19th March 2025

**Former Royston Working mens club, 52 Church Street, Royston, Barnsley S71 4QU -
Pre-Planning Sewerage Enquiry V819620**

Dwg No. : STE/25/06/01
Date : 26-3-25
Scale : 1:200

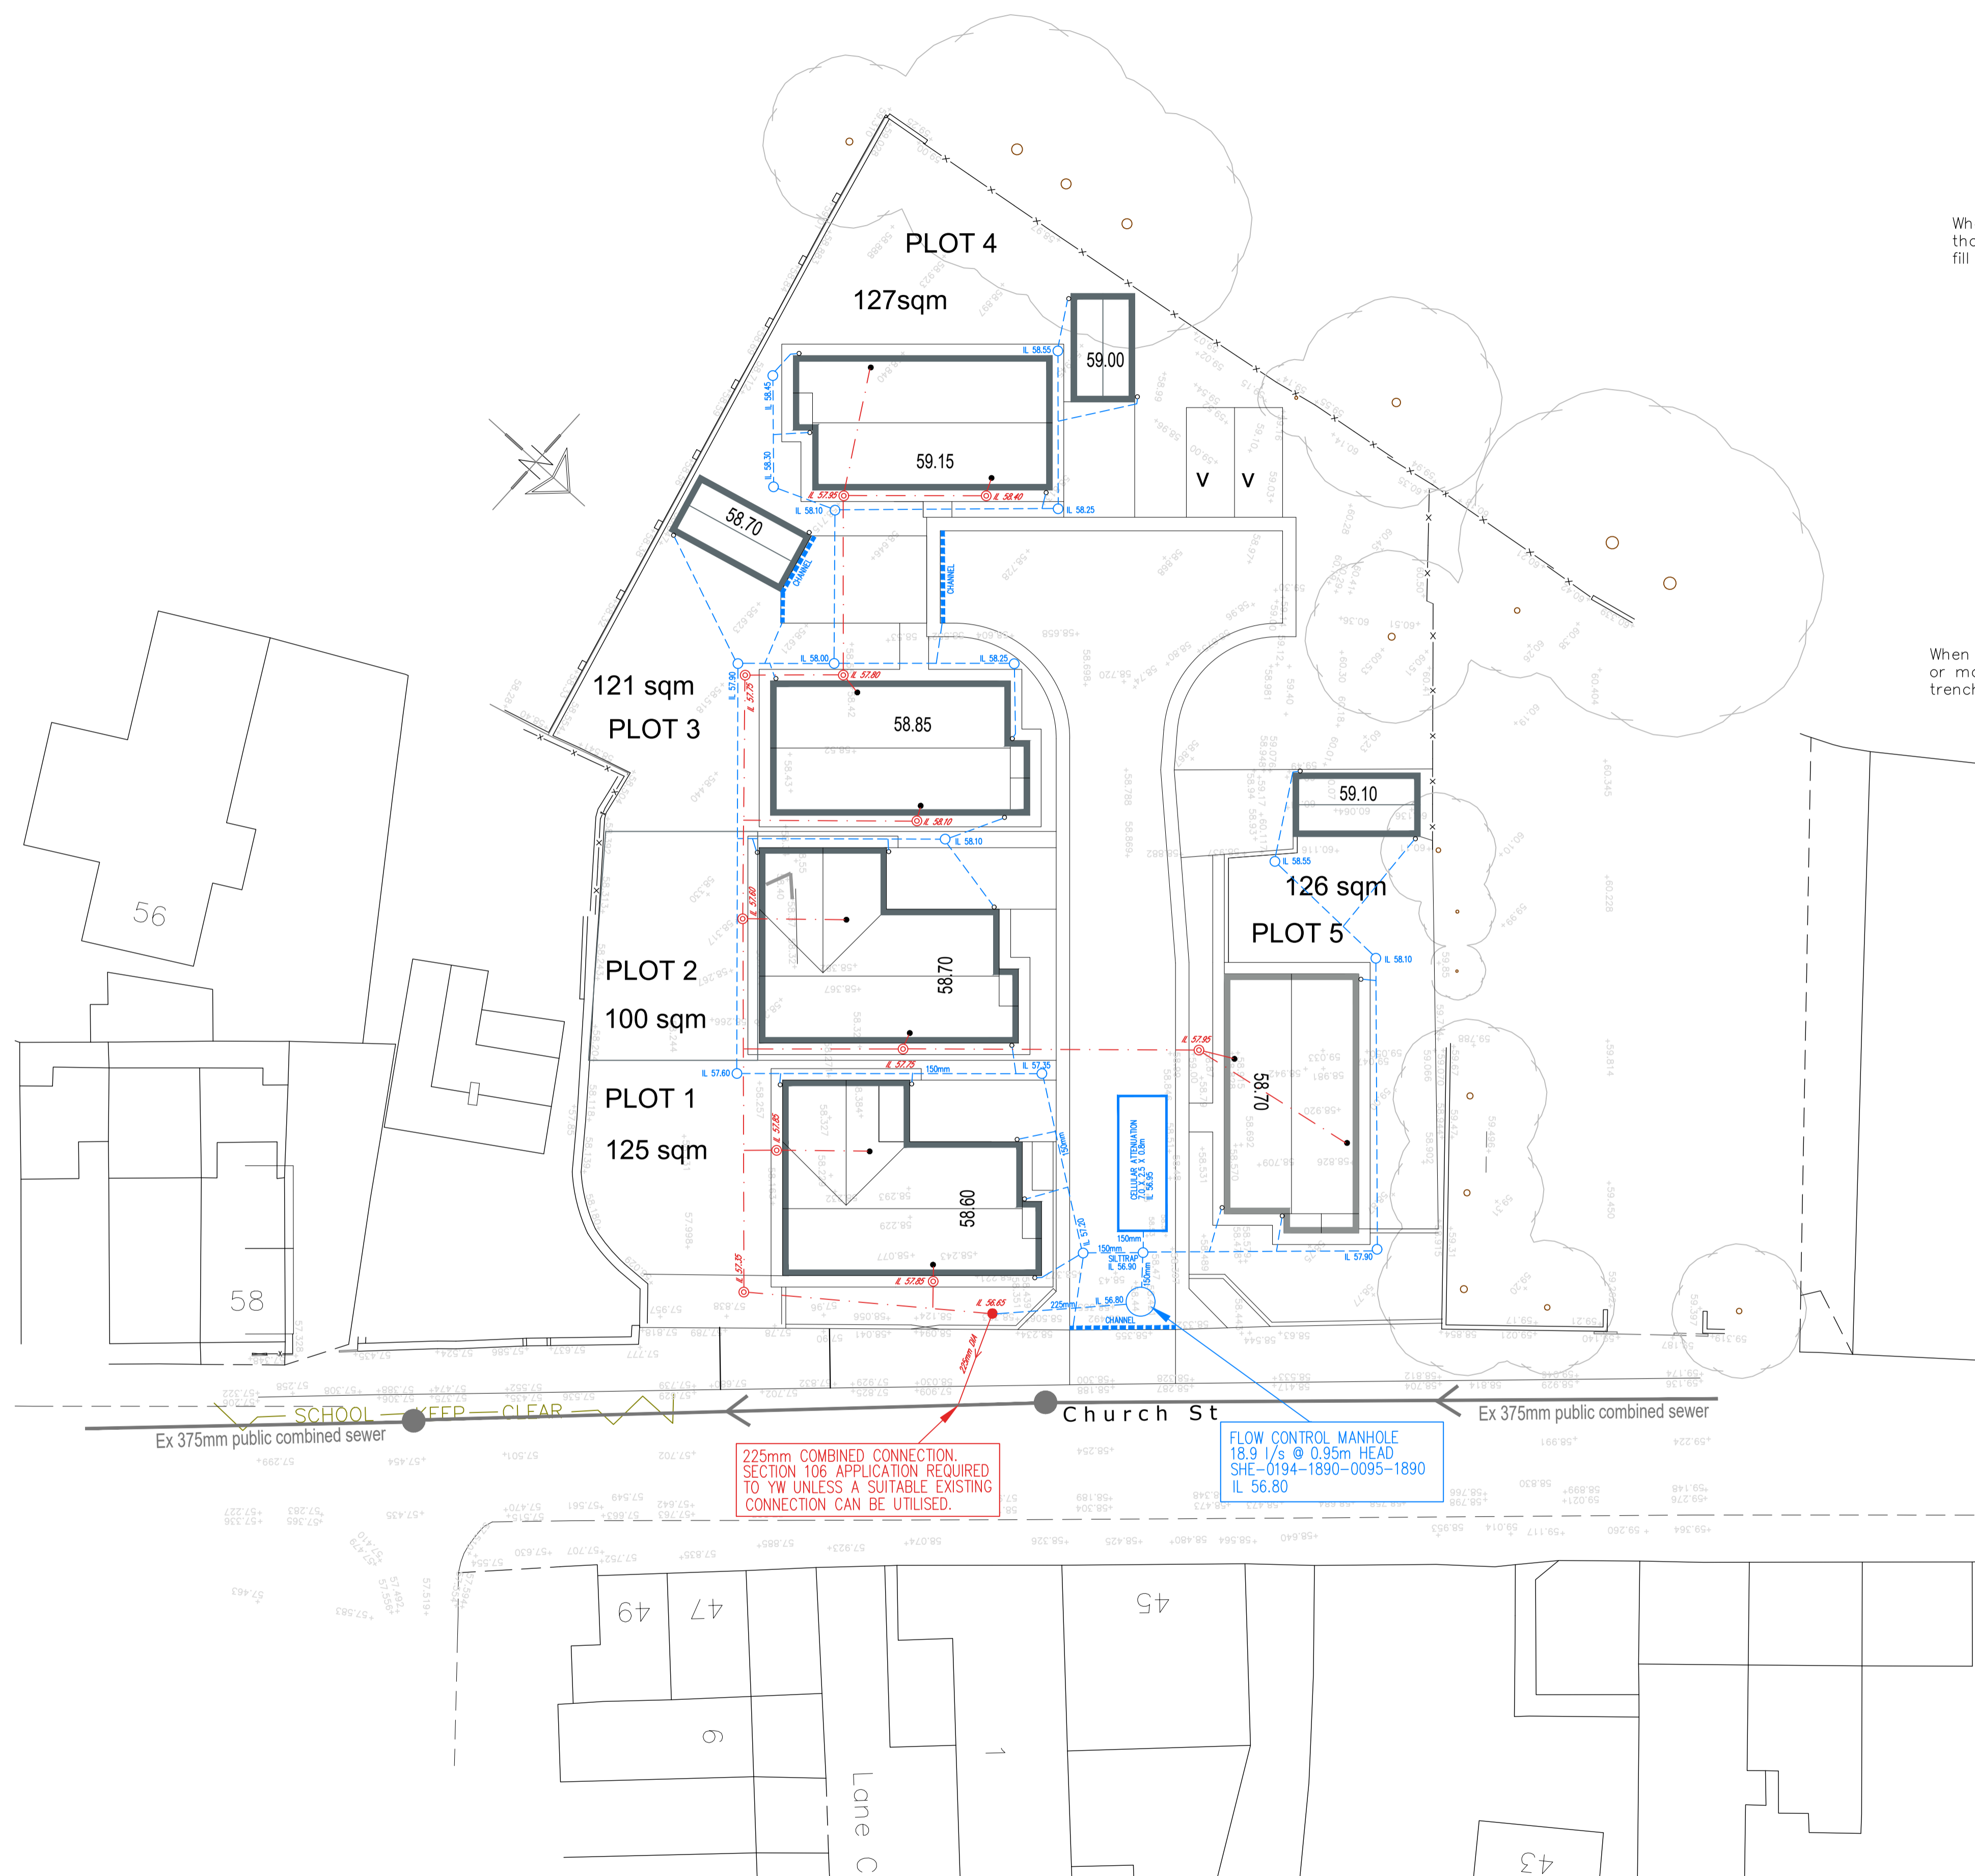
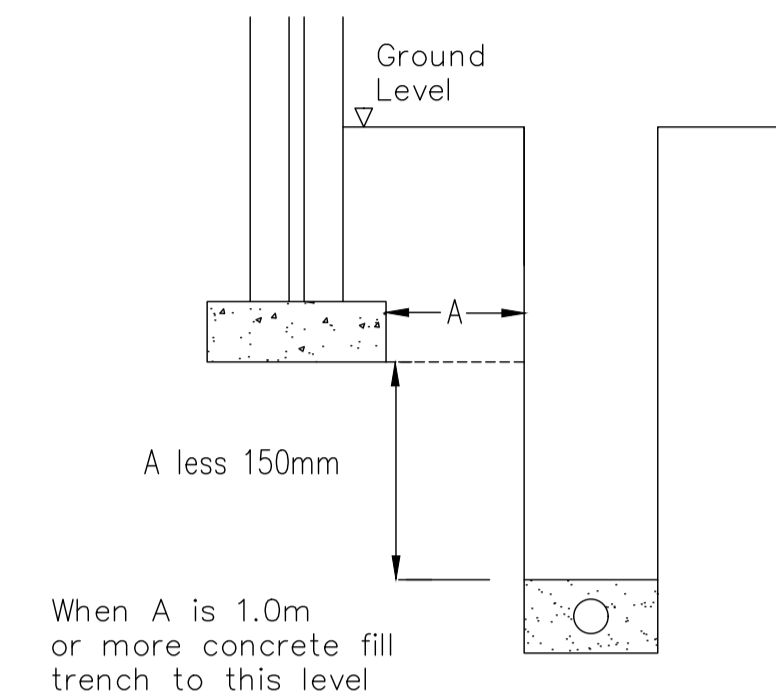
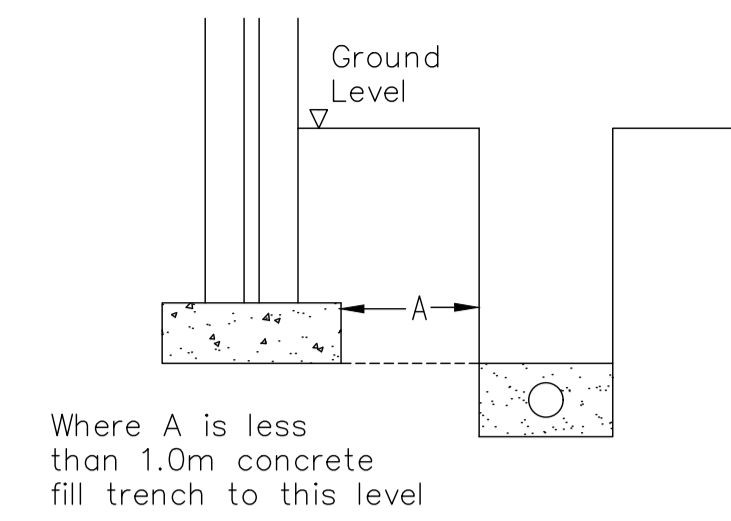
Foul water domestic waste can discharge to the 375 mm diameter public combined sewer recorded in Church Street.

Submitted infiltration testing has shown soakaways are not suitable in this instance.

There is a highway drain on Church street that may prove a suitable means of surface water disposal - Connection subject to approval from the highways authority.

As a last resort and subject to providing satisfactory evidence as to why the other methods of surface water disposal have been discounted, curtilage surface water may discharge to the to the 375 mm diameter public combined sewer recorded in Church Street, at a restricted rate not to exceed 18.9 litres per second.
